WHS Tree Services
Footings
Gatewick Farm
Steyping
BN44 3SF

Please ask for: Nicola Moore
Email: nicola.moore@arun.gov.uk
Telephone: Ext 37944
Our Ref: FG/170/20/T
Your Ref:
Date: 21st December 2020

Application for Works to Trees(s) subject to a Tree Preservation Order(TPO)

Development: T1 - T6 AS SHOWN ON PLAN - 6 X AUSTRIAN PINE

Plan showing location of trees

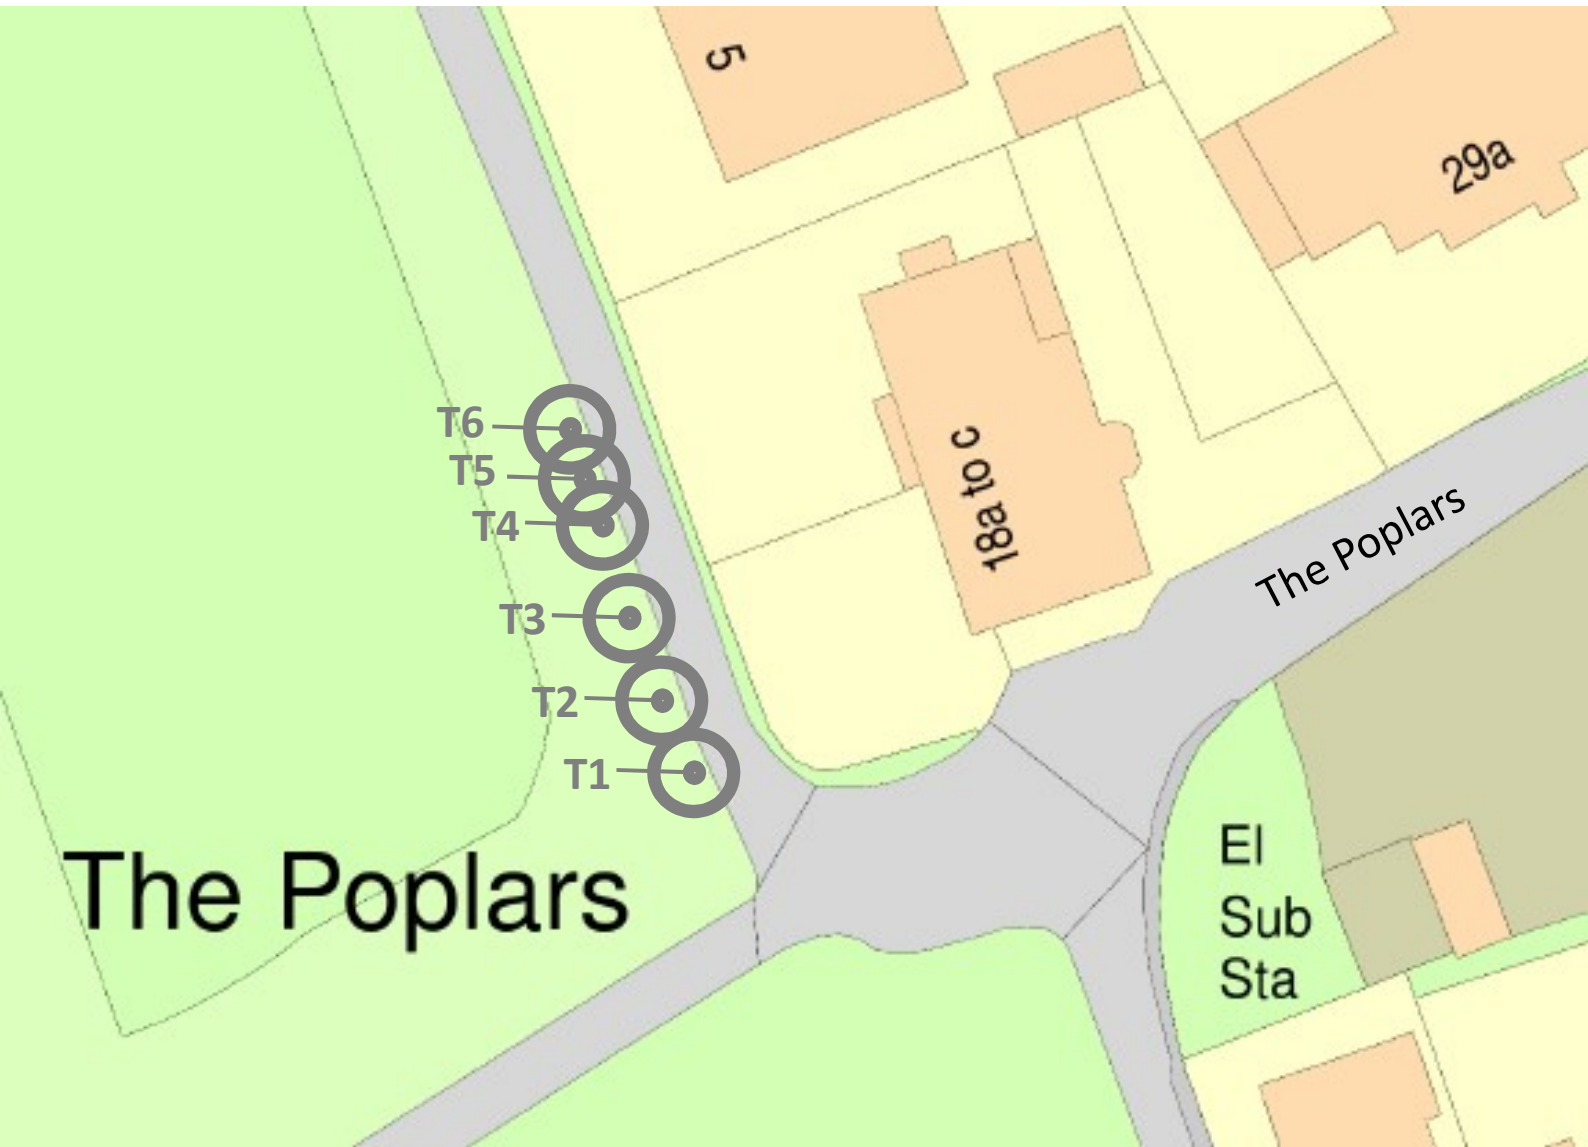
Please provide the proposed lateral spread measurement for each tree after proposed reduction.
